CITY OF ALBUQUERQUE

January 2, 2024

Re: 2900 Central
2900 Central Ave. SE
Traffic Circulation Layout
Engineer's Stamp 12-01-23 (K16-D009A)

Based upon the information provided in your submittal received 12-20-23, the above referenced plan cannot be approved for Building Permit until the following comments are addressed:

TCL1

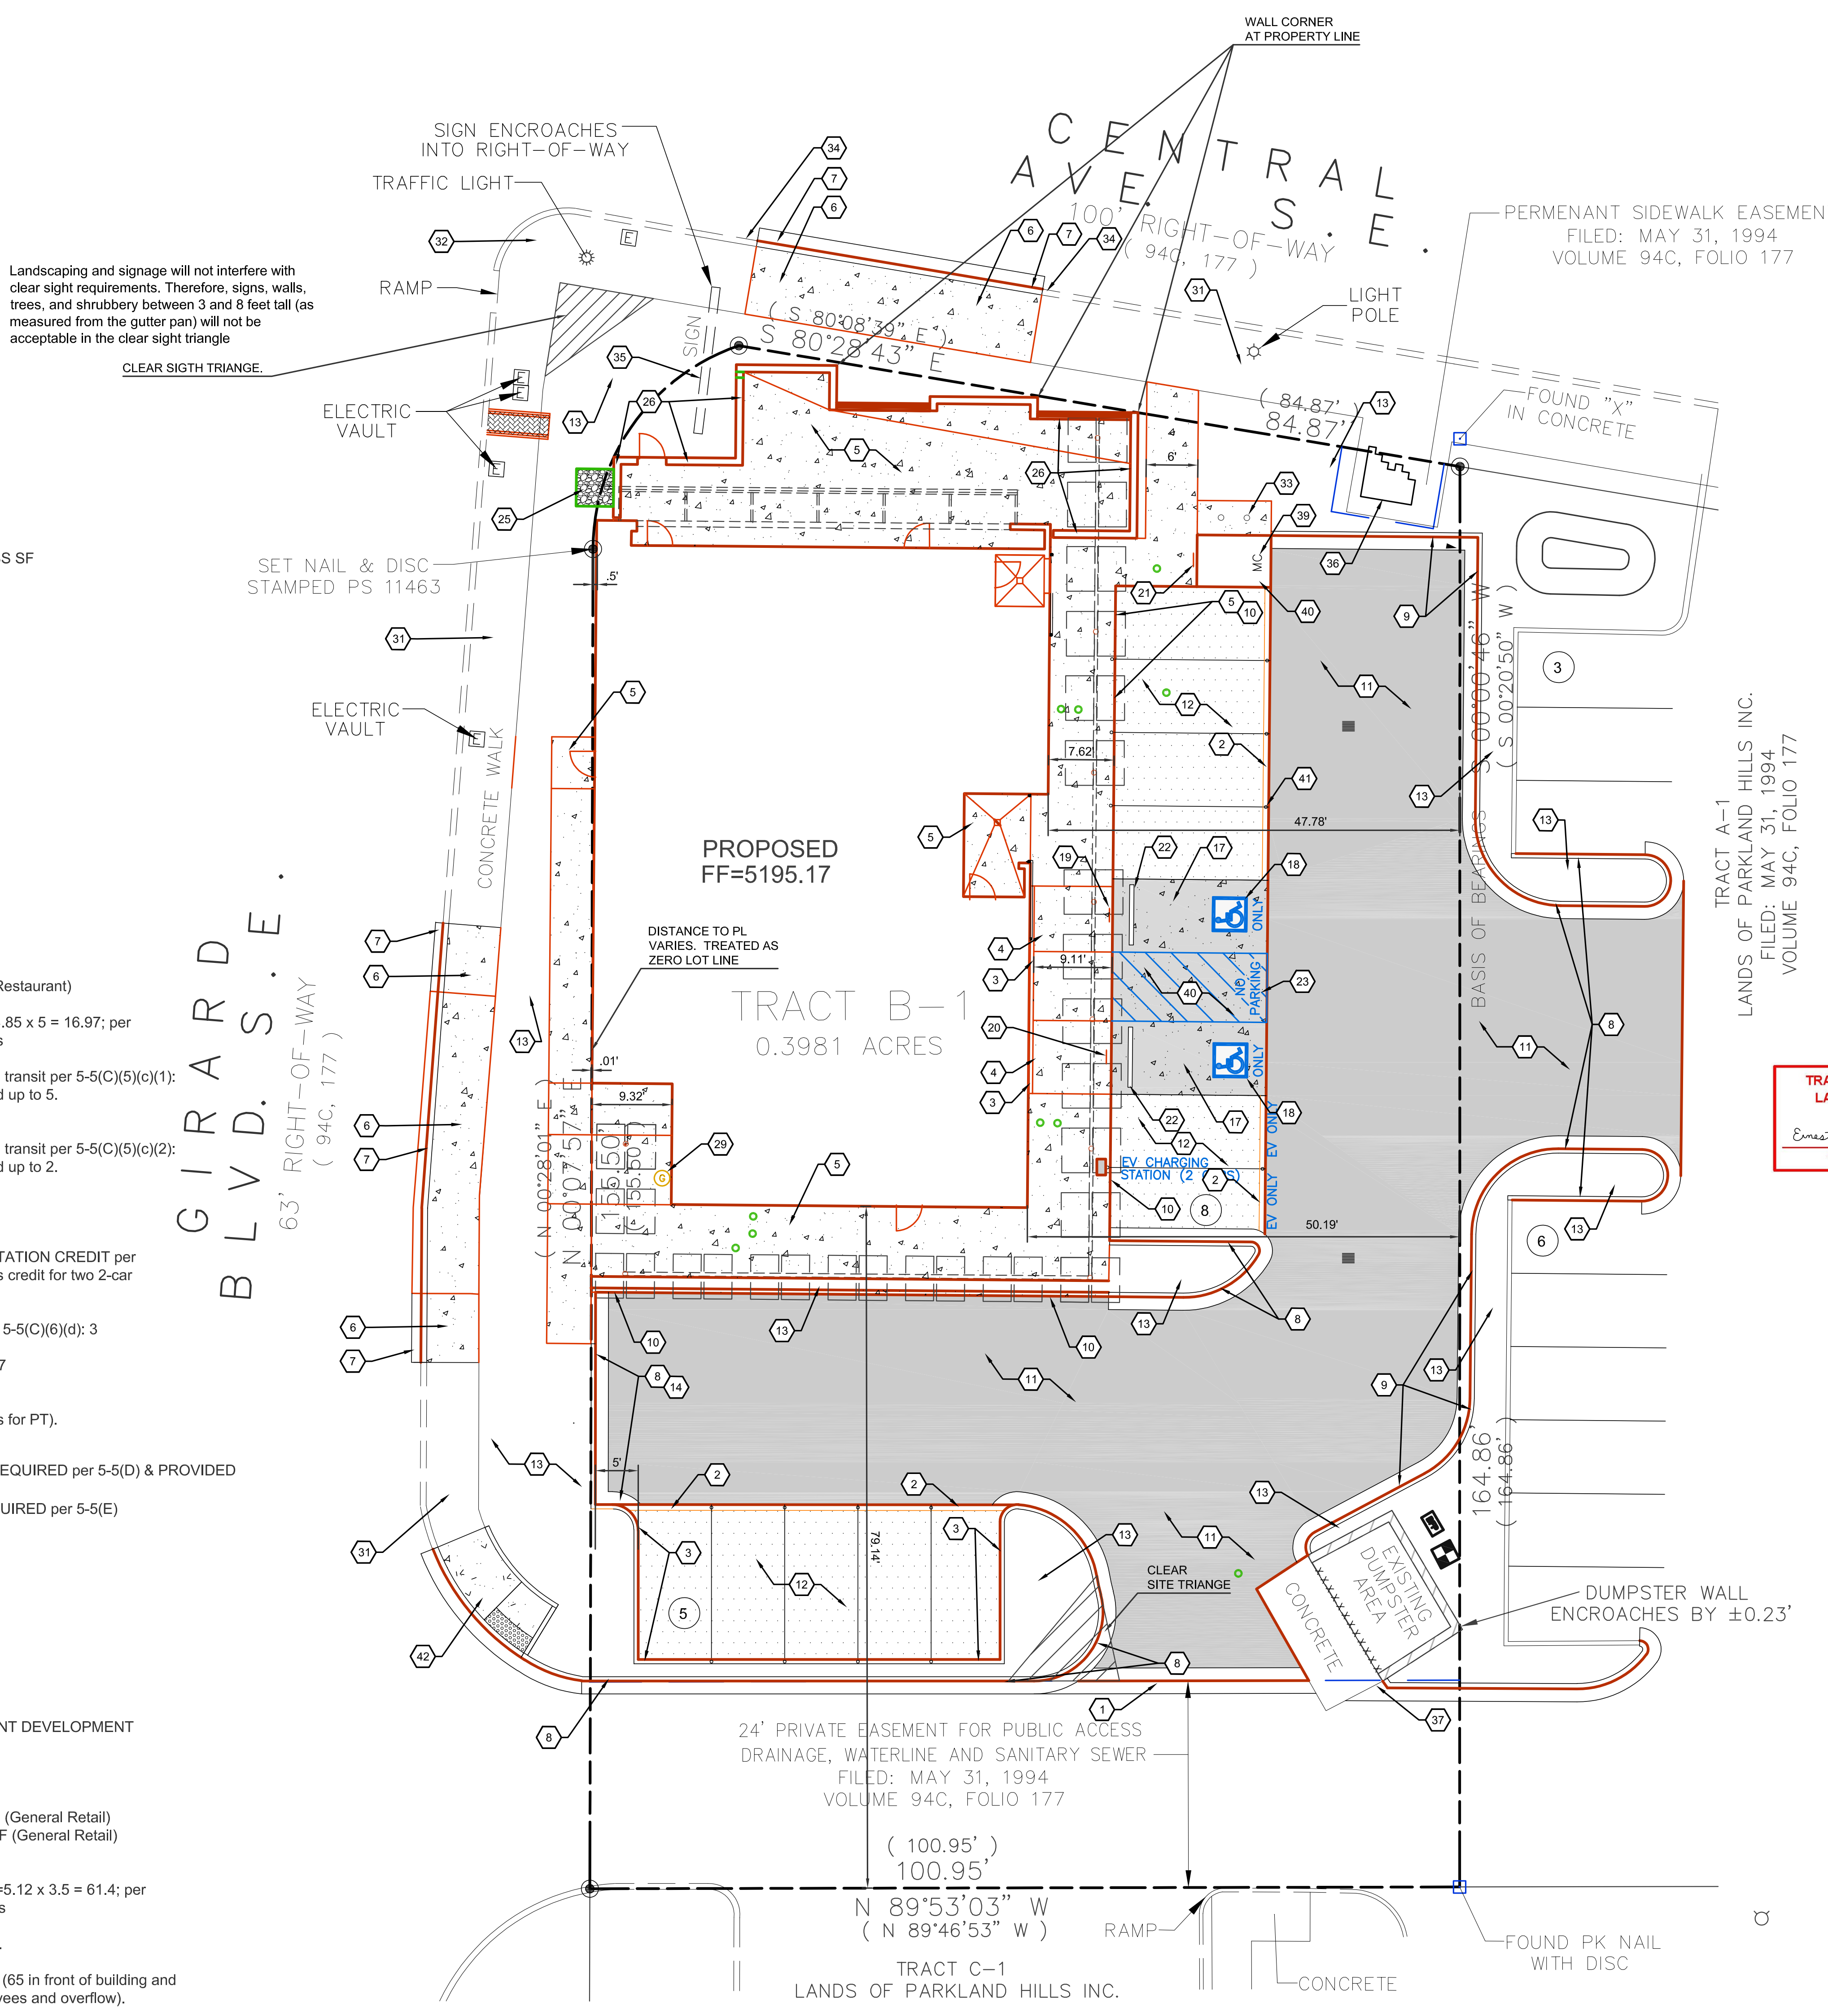
7. Please remove any non related transportation details from sheet C502, such as details E1,2,3,D5, and A5.
8. It appears there are two signs encroaching into right of way, either remove them or a revocable permit is required.

TCL2

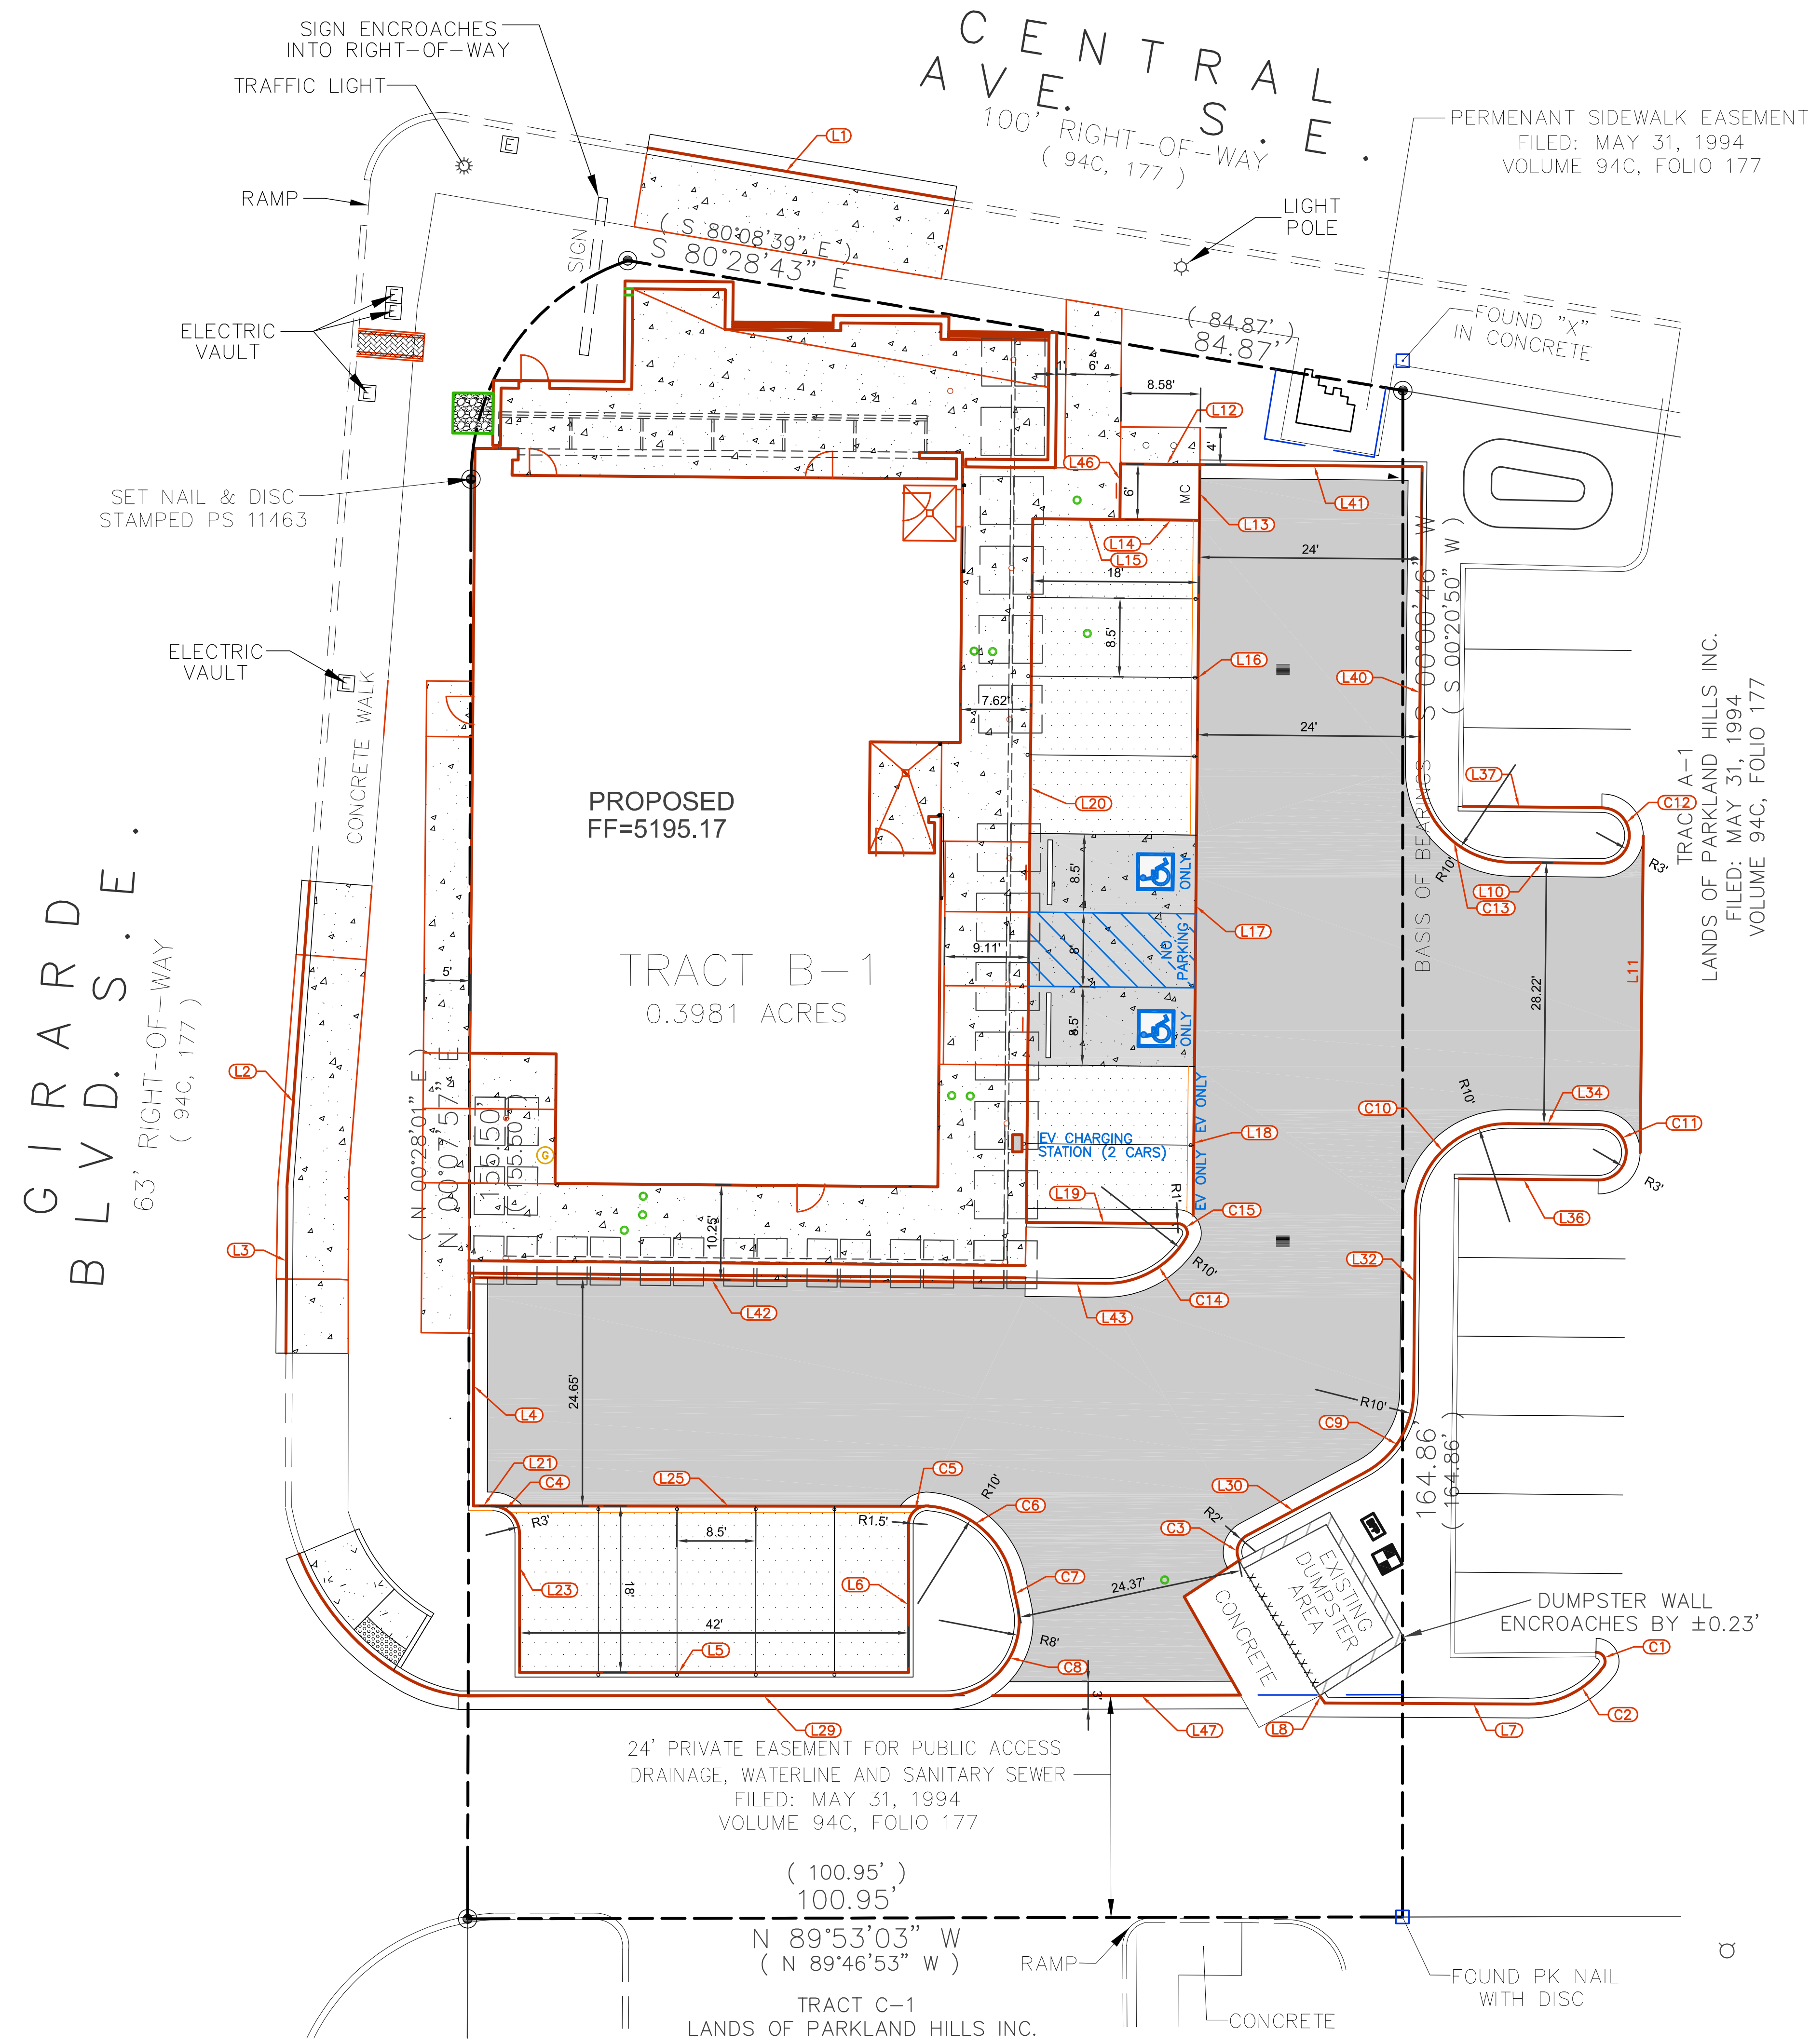
1. Please show a vicinity map showing the location of the development in relation to streets and well-known landmarks.
2. Identify all existing access easements and rights of way width dimensions.
3. Please provide shared parking agreement with east side property.
4. Due to proposed new site access and removing some parking spaces from the east side property, please submit shared access agreement and parking calculation. This documentation should demonstrate that the remaining parking spaces on the east property still meet the required standard. Also, please provide the width for this access.

5. The ADA accessible parking sign must have the required language per 66-7-352.4C NMSA 1978 **"Violators Are Subject to a Fine and/or Towing."** Please call out detail and location of signs.
6. Show on the site plan this sidewalk width.

10. Provide a copy of Fire Marshal approval.
11. Show the clear sight triangle and add the following note to the plan: "Landscaping and signage will not interfere with clear sight requirements. Therefore, signs, walls, trees, and shrubbery between 3 and 8 feet tall (as measured from the gutter pan) will not be acceptable in the clear sight triangle.

12. Add a note stating "All broken or cracked sidewalk must be replaced with sidewalk and curb & gutter." A build note must be provided referring to the appropriate City Standard drawing.
